**From:** Nicholas Hon  
**Sent:** Monday, 14 September 2020 4:22 PM  
**To:** Emily Murray  
**Cc:** Doris Yau  
**Subject:** RE: Newcastle Power Station - updated PHA and PHA Addendum for Amendment Report

I refer to the following published documents in relation to the proposed AGL Newcastle Gas-fired Power Station (SSI 9837):

In reviewing the above documents, we consider our queries to have been adequately addressed and incorporated within [PHA 3 – AR Appendix E] and [PHA add. – AR Appendix F]. Therefore, we consider these documents to constitute the finalised Preliminary Hazard Analysis (PHA) for SSI 9837 and provide our advice on this basis. The PHA generally aligns with the AR.

Process Flow Diagram

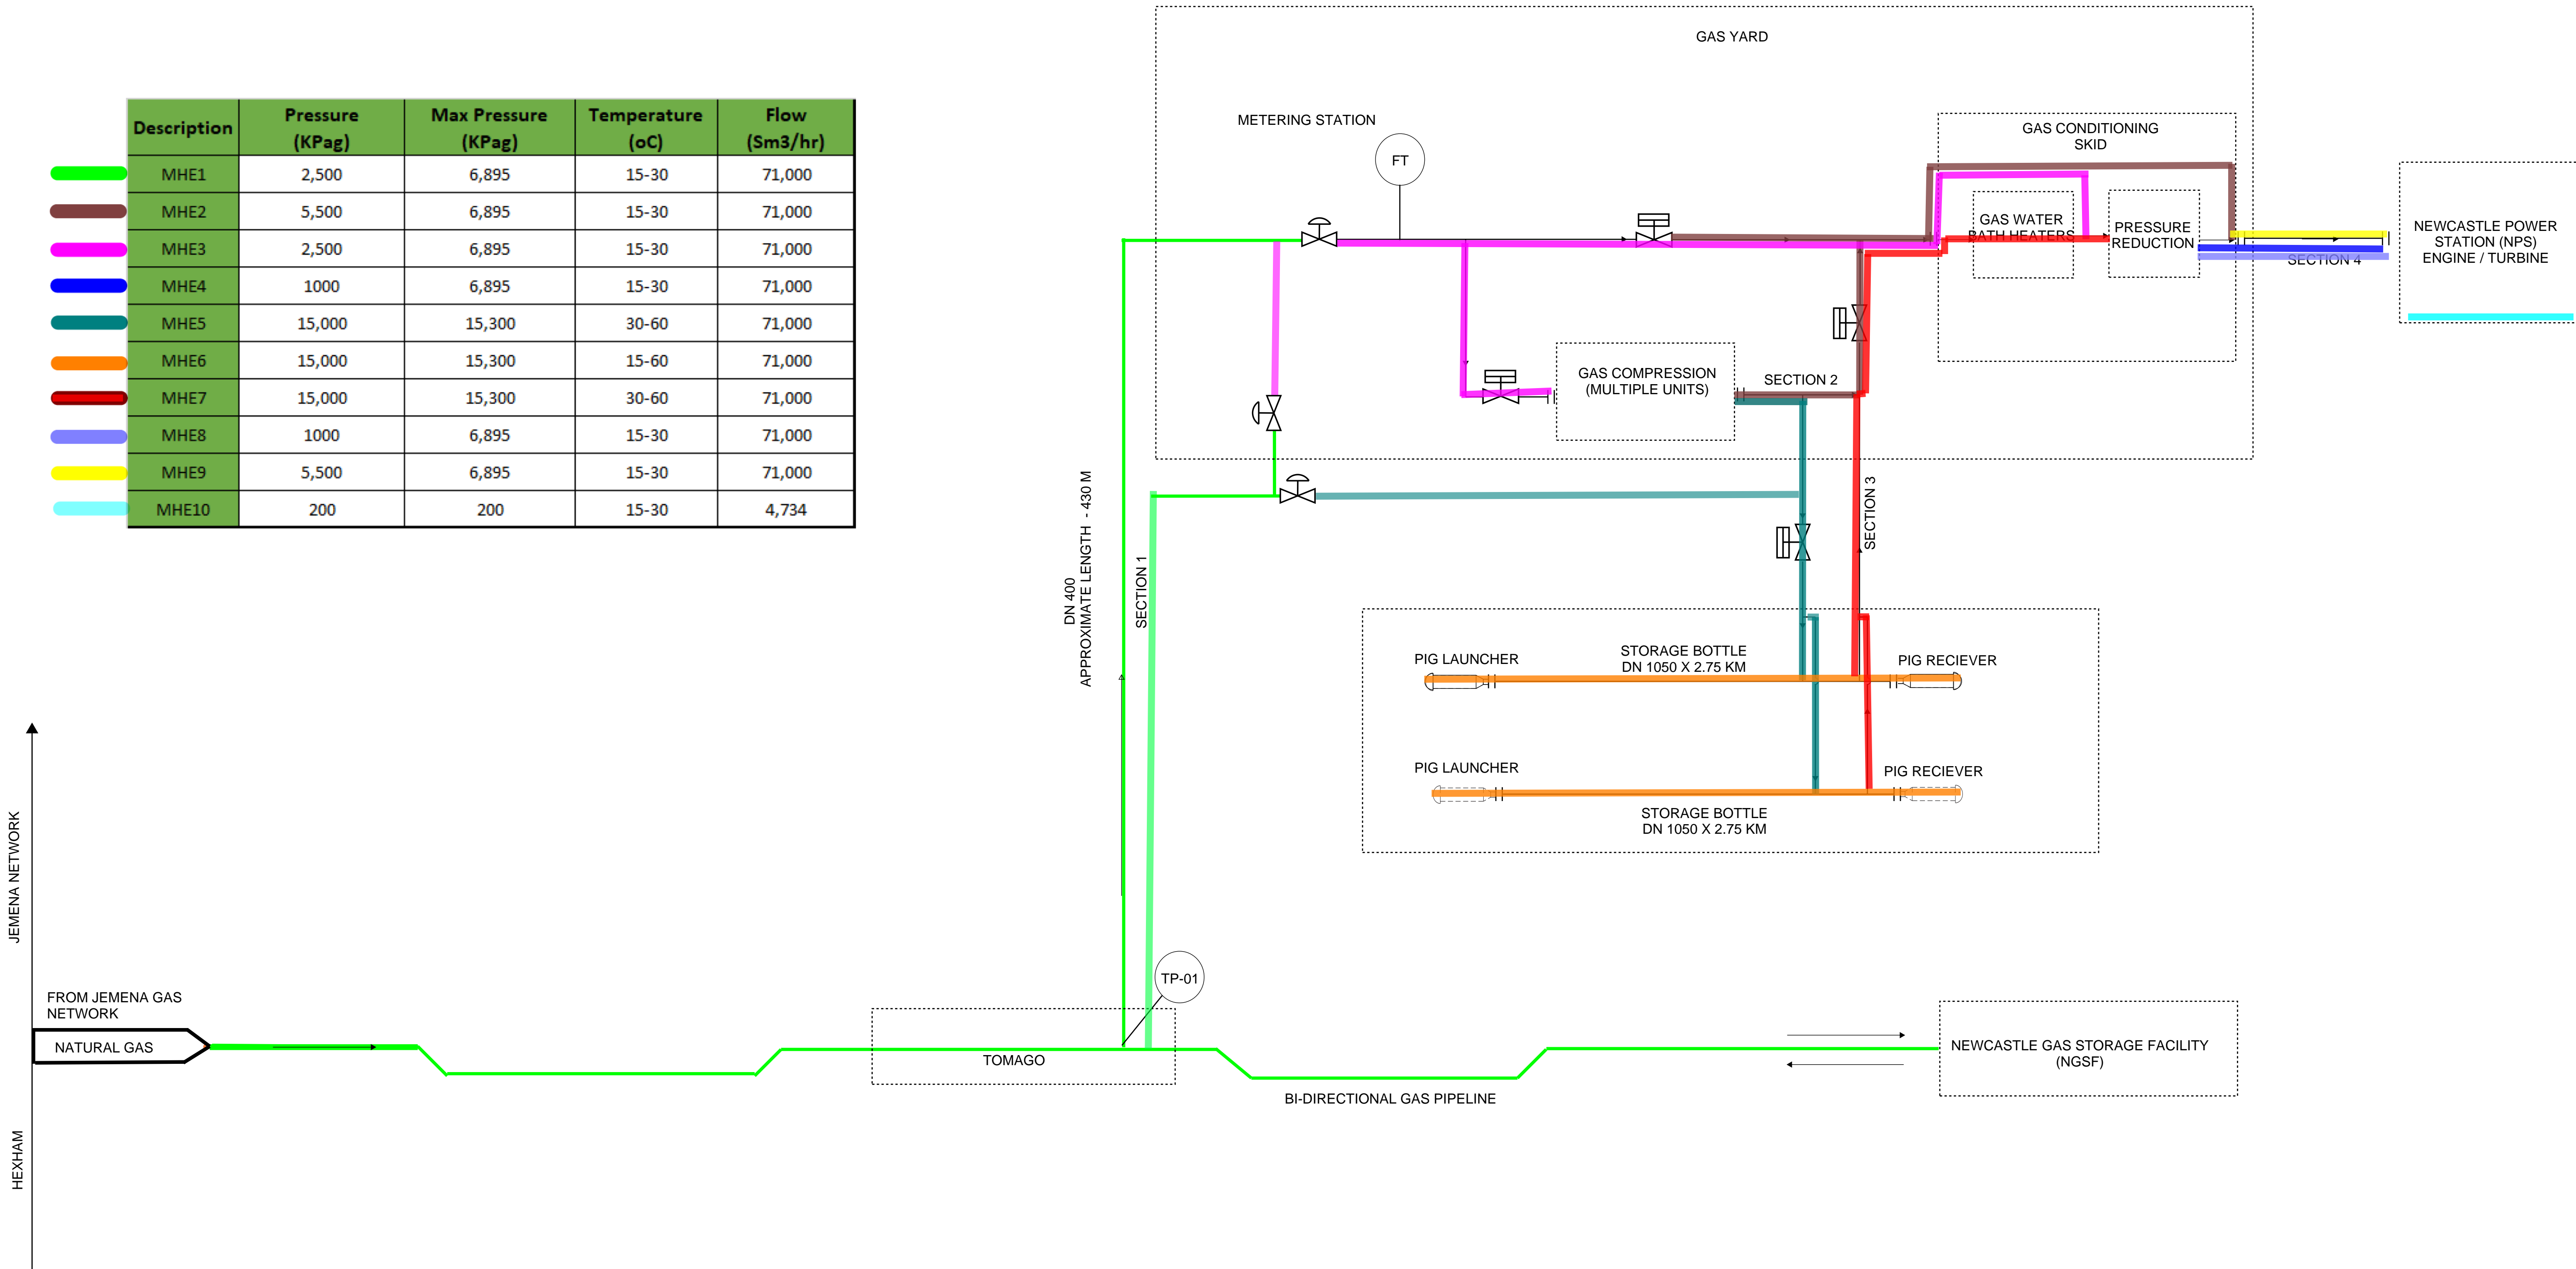
It should be noted that gas is not supplied to the SSI directly from the existing AGL NGSF but through the existing JGN high-pressure gas pipeline only, as described in PHA Appendix 3. As such, a **limit of consent** should be applied on this basis.

1. The Applicant must ensure that gas or material flows associated with the project and its components are in accordance with the process flow diagram in Appendix 3 of the *Preliminary Hazard Analysis* (revision 6, dated 13 August 2020) without any direct gas or material flows between the project and the existing AGL Newcastle Gas Storage Facility (MP 10\_0133).
2. The Applicant must not commission or operate any high-pressure gas pipeline capable of supplying the power station, including the 5.5 km DN 1050 gas storage system, without satisfying all requirements under the *Pipelines Act 1967*.
